MEMORANDUM TO: Division Environmental and Construction Units

SUBJECT: Environmental Permits for the Improvements to NC 150 in Catawba and Iredell Counties Division 12, **TIP: R-2307.**

Permit Site Changes between 2020 and 2024 Permitting:

**PERMIT DRAWING  
SHEET 2 OF 22**

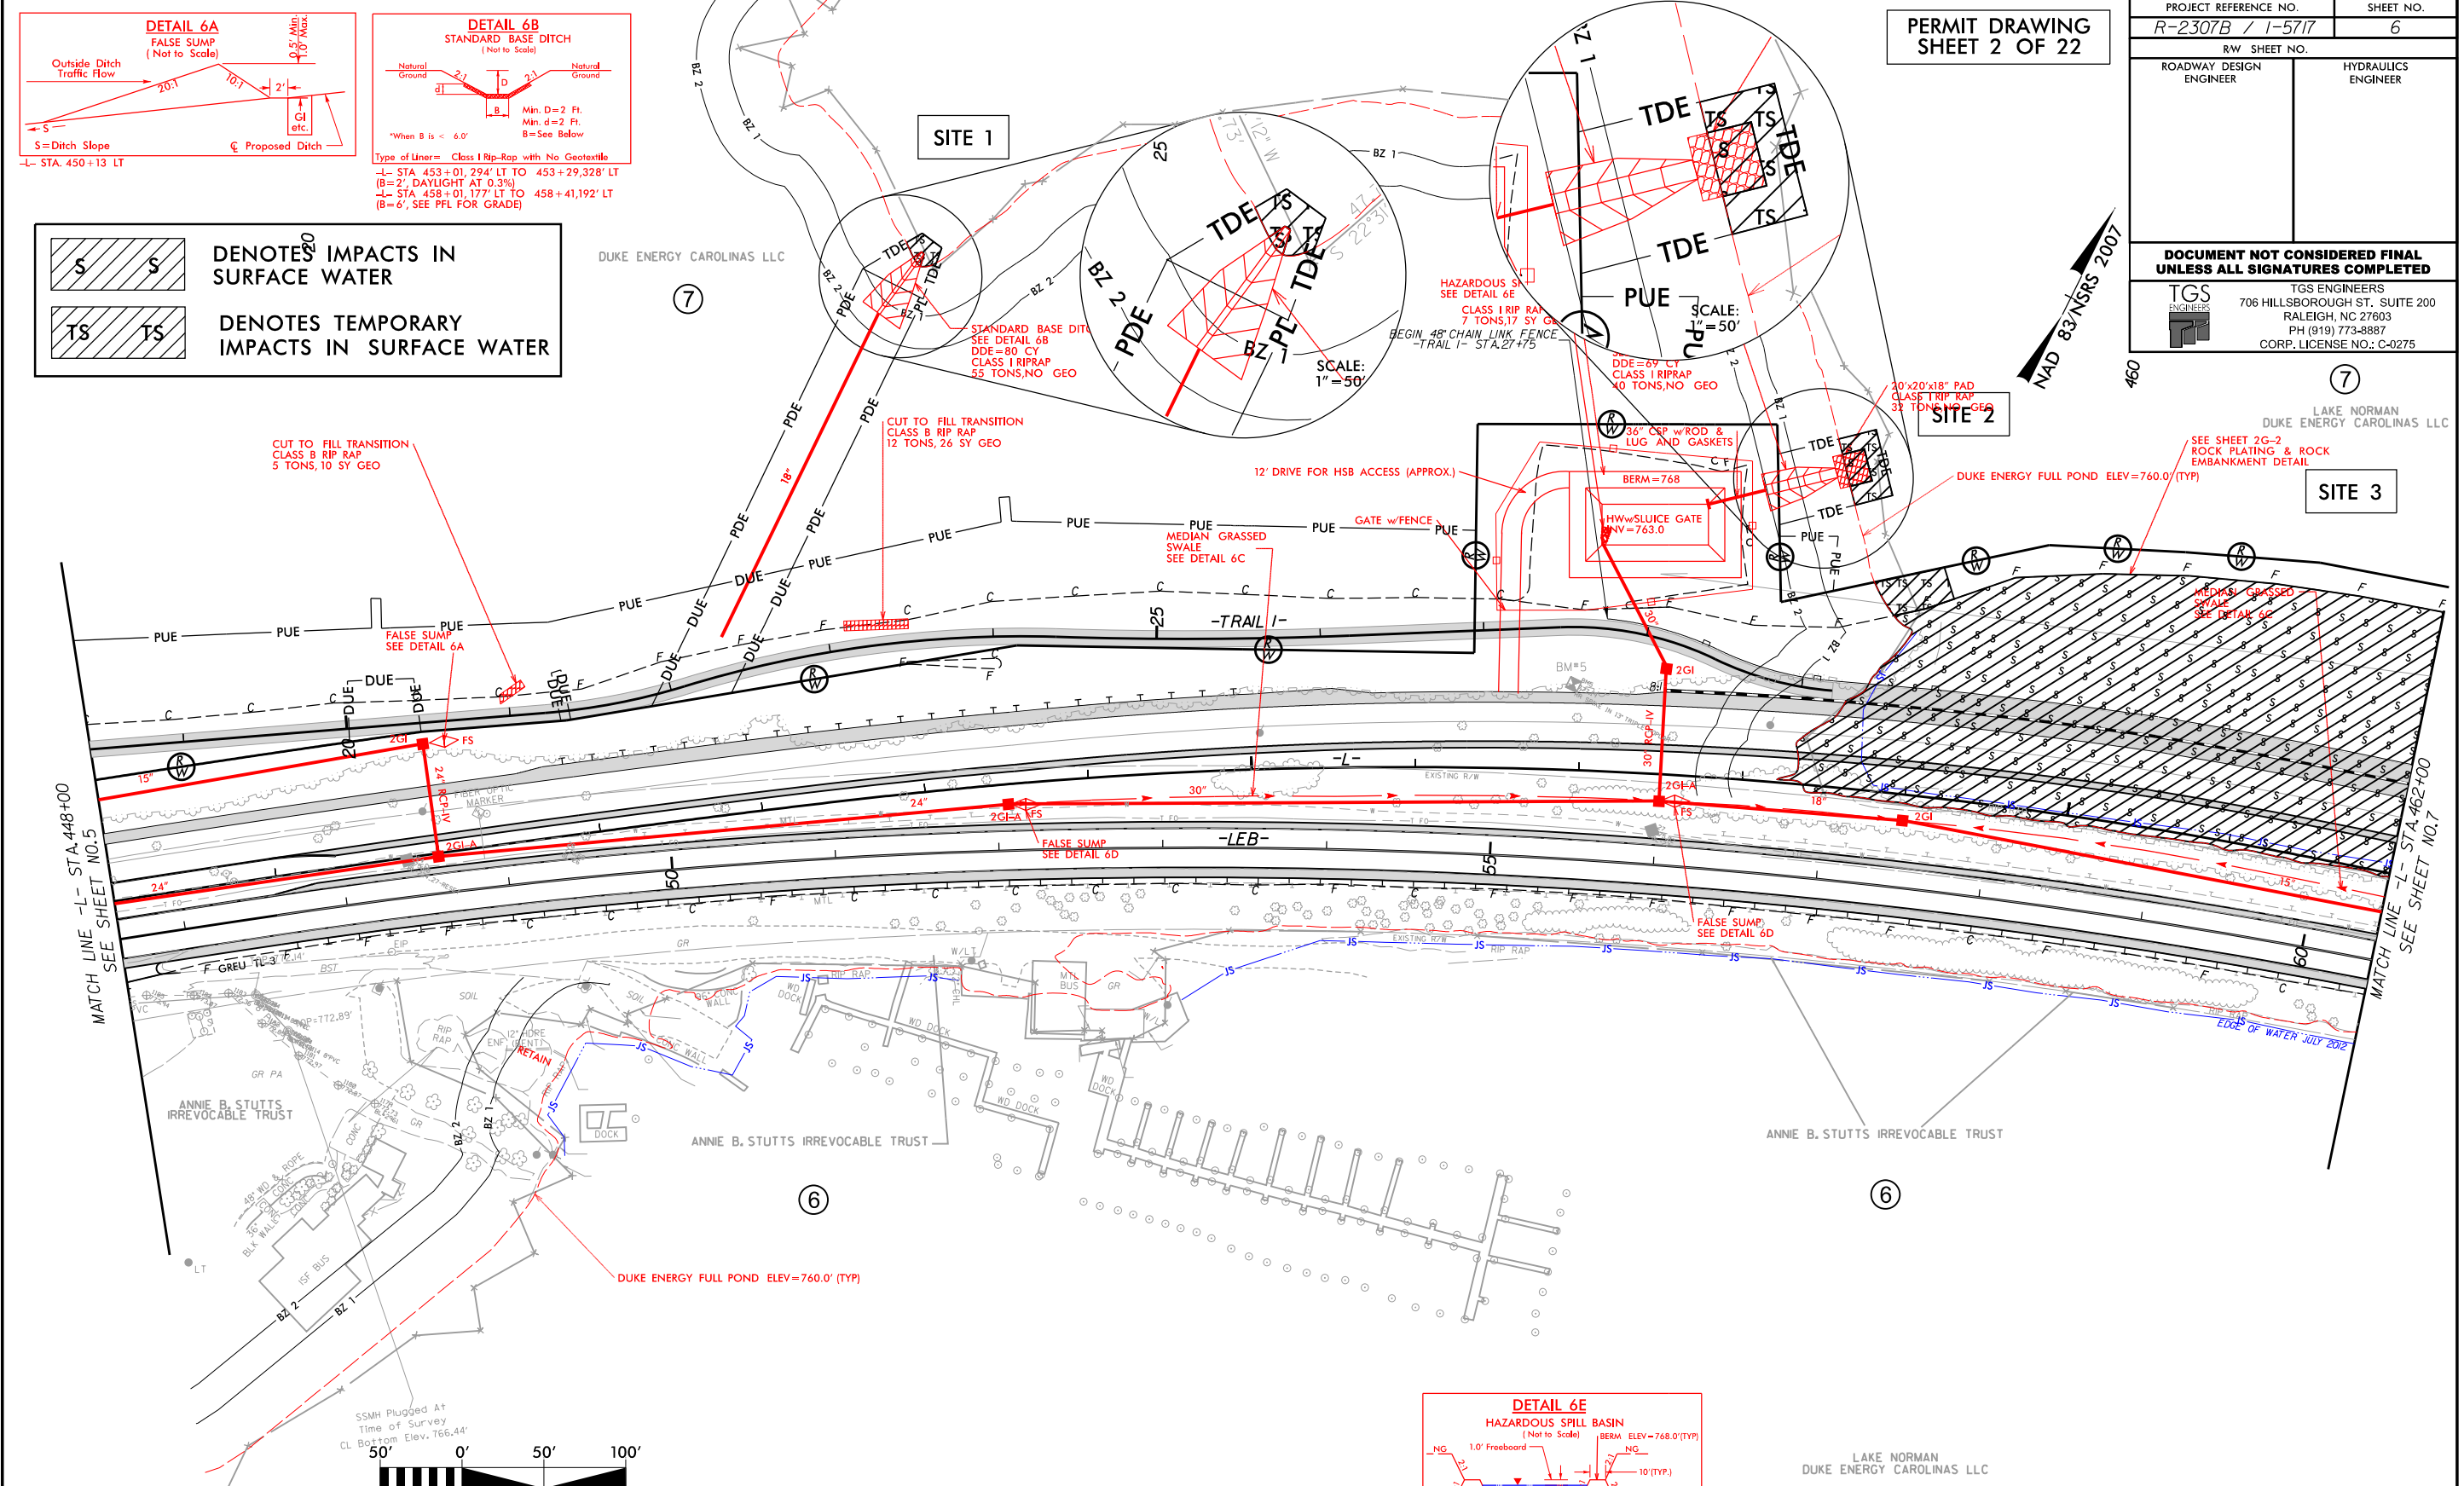
Site 3: Three temporary Surface Water Impacts were added down to elevation 750 ft on Permit Drawing Sheets 2-5. Temporary Surface Water Impacts increased from 0 to 0.070 acre.

PERMIT DRAWING  
SHEET 5 OF 22

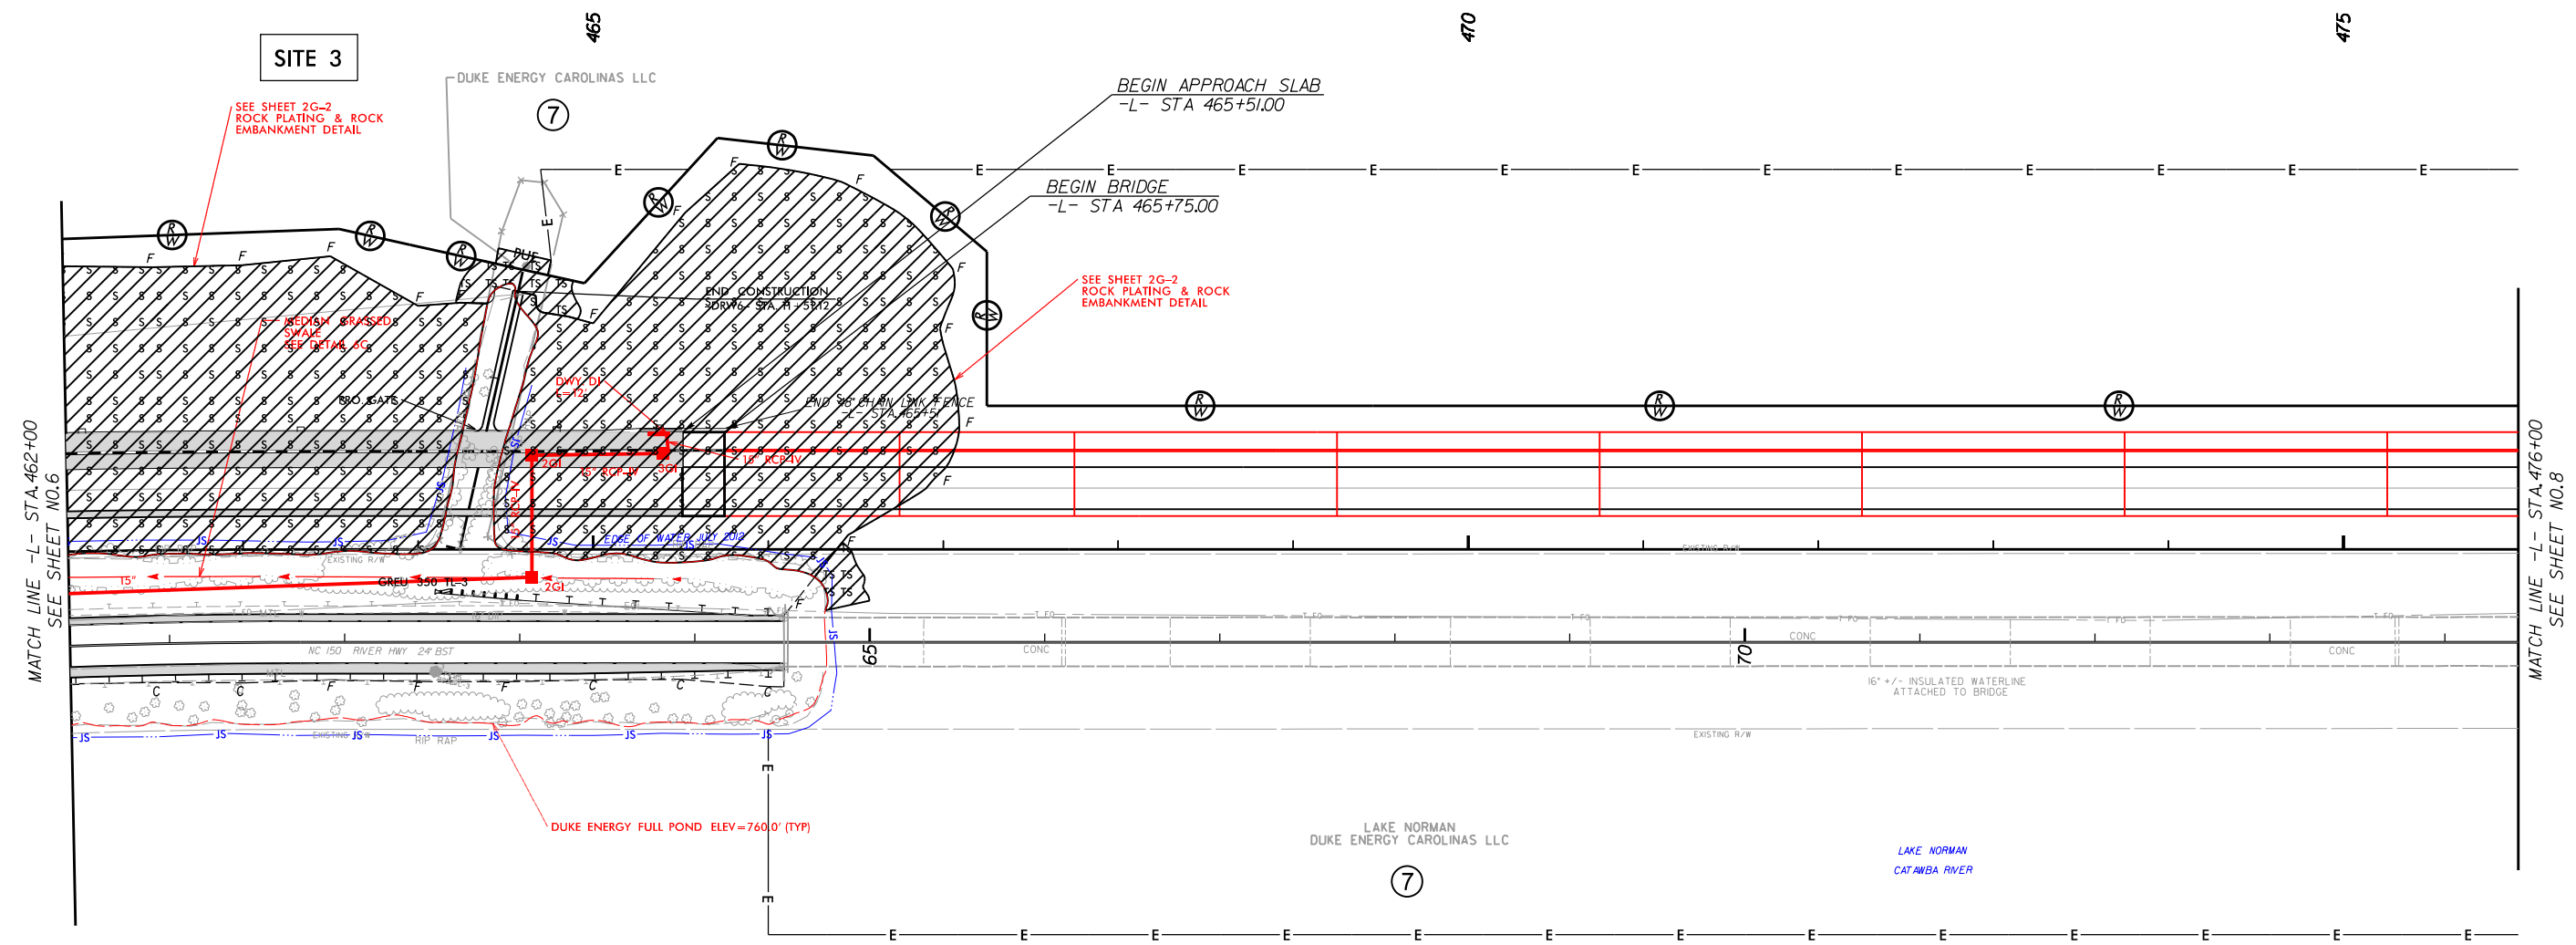
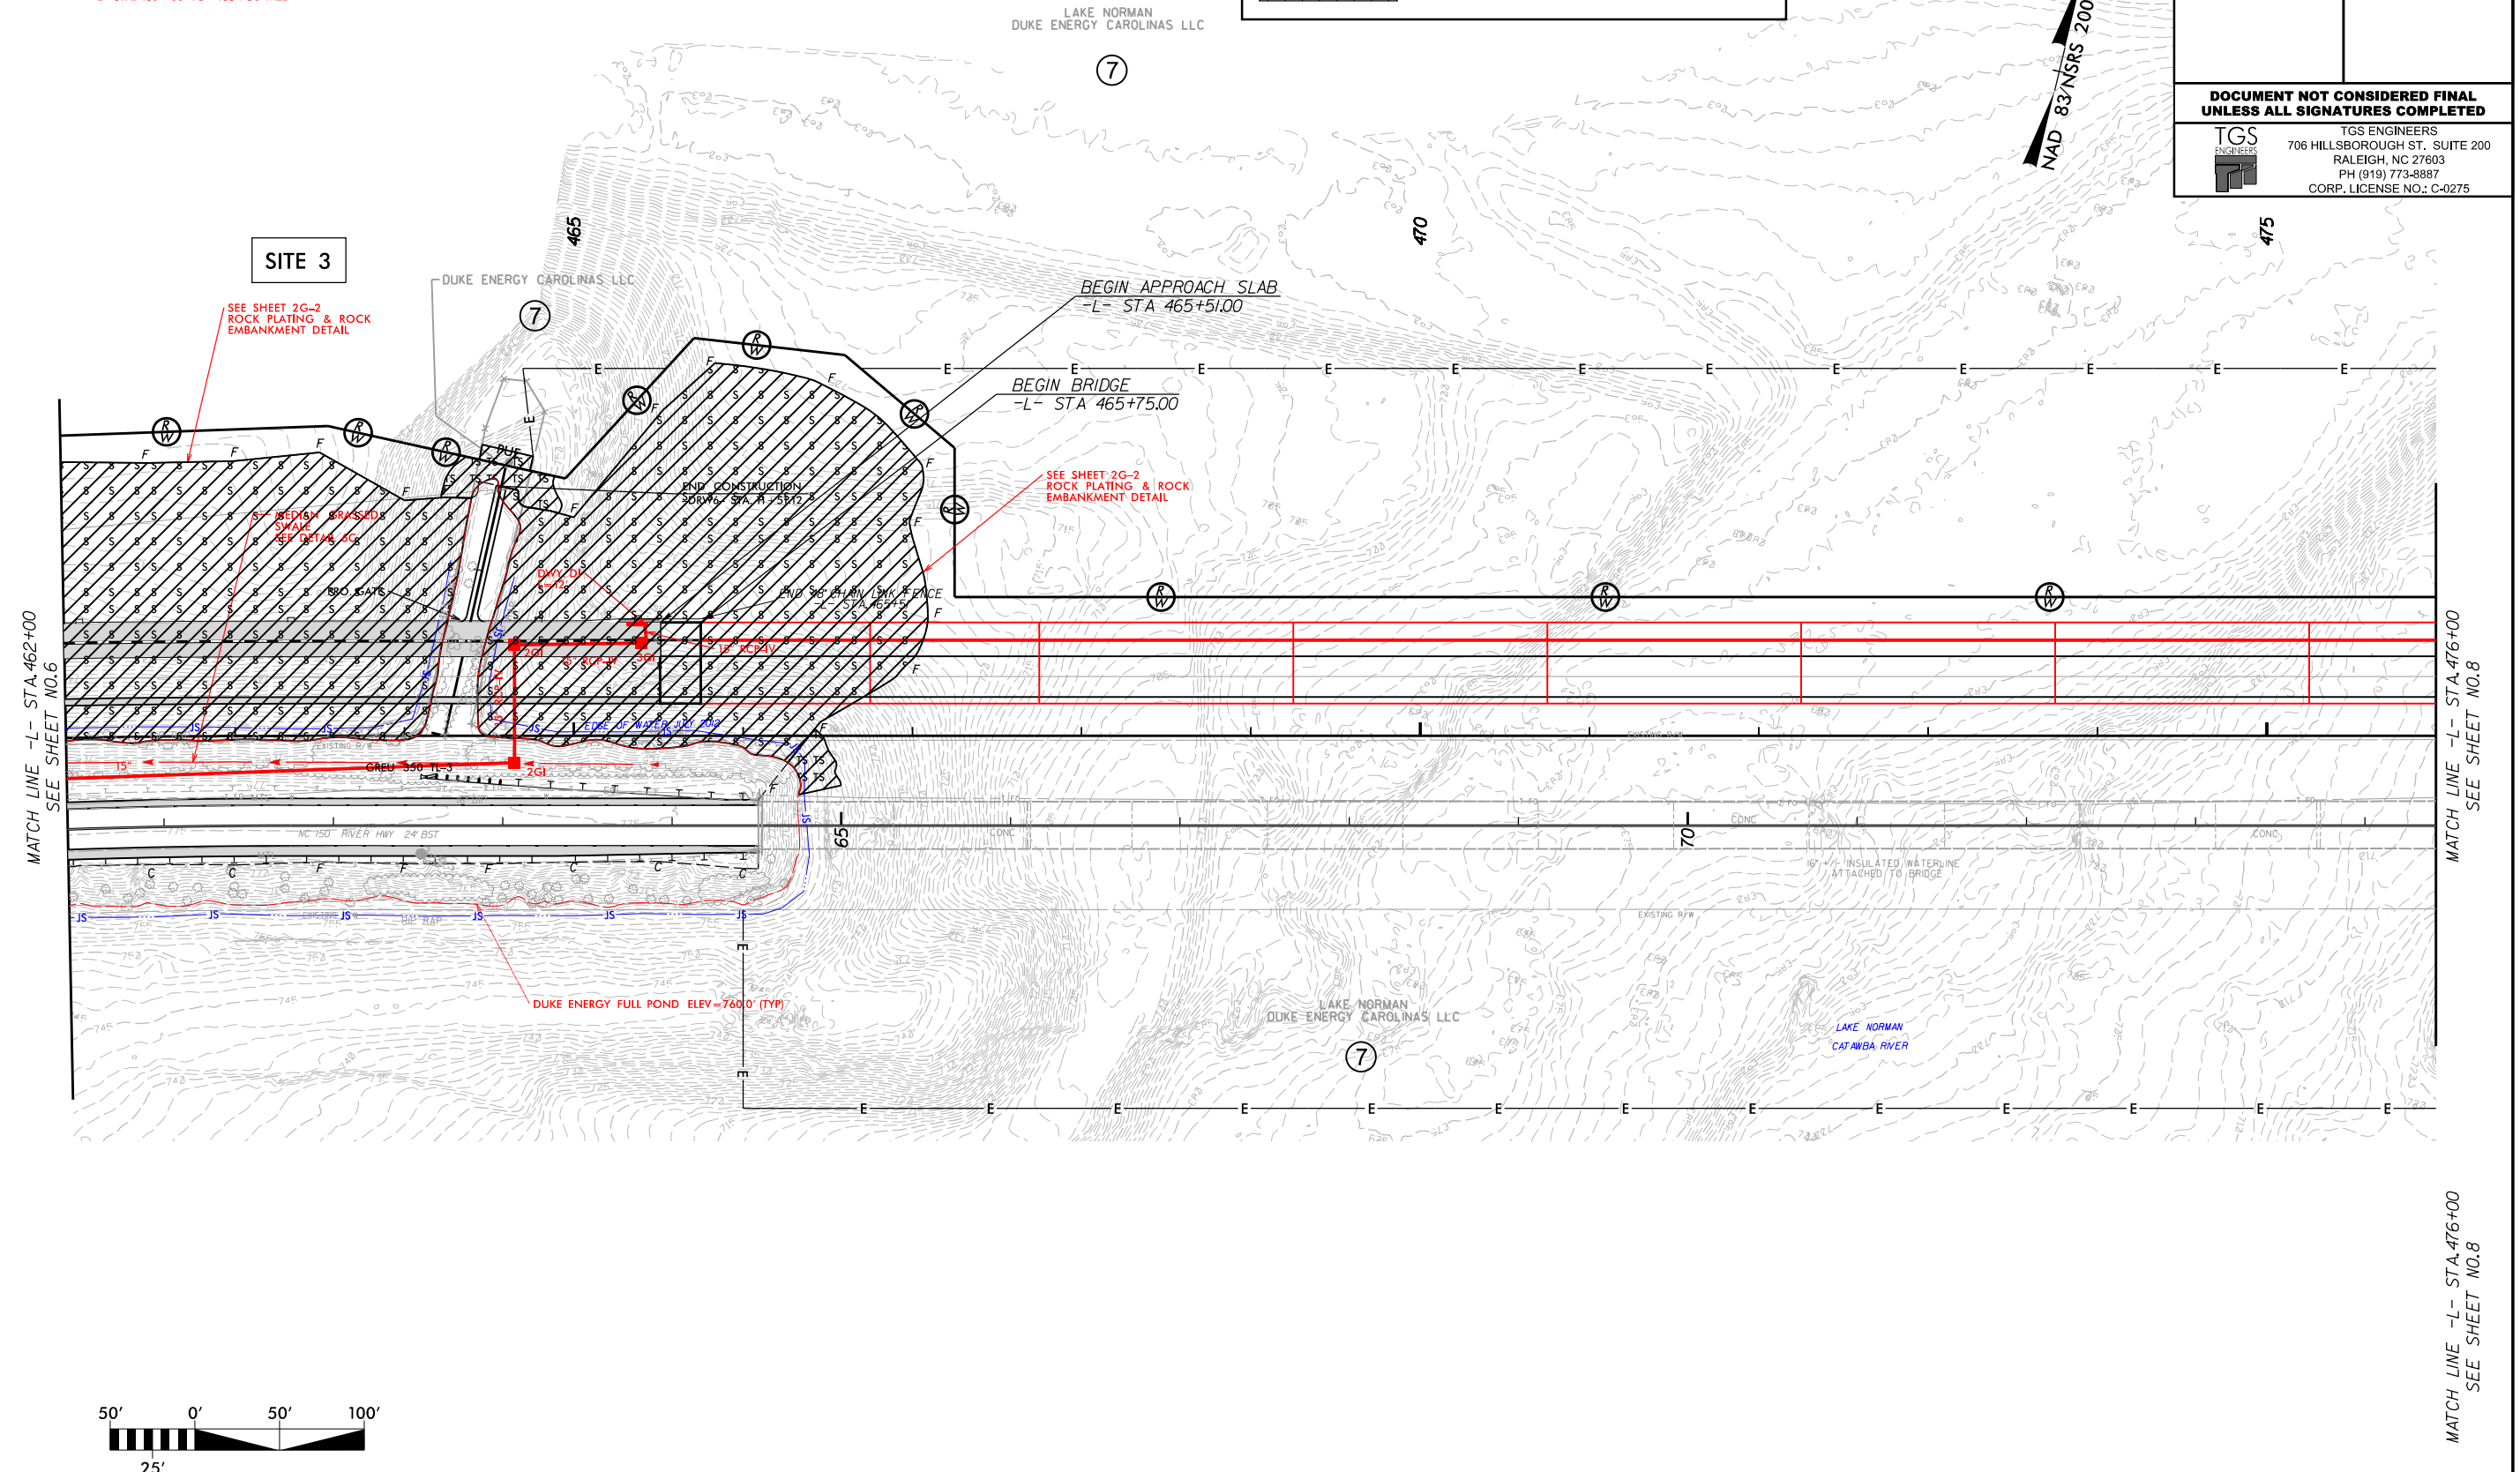
Site 3/ Permit Drawing Sheets 4-6: Due to concerns from Duke Energy regarding boater safety and the alignment of bridge piers with the existing structure, the proposed bridge span arrangement was modified to better match the existing bridge. Permit Drawing Sheets 4-6 and associated footnote on the Impact Summary Sheet were updated.
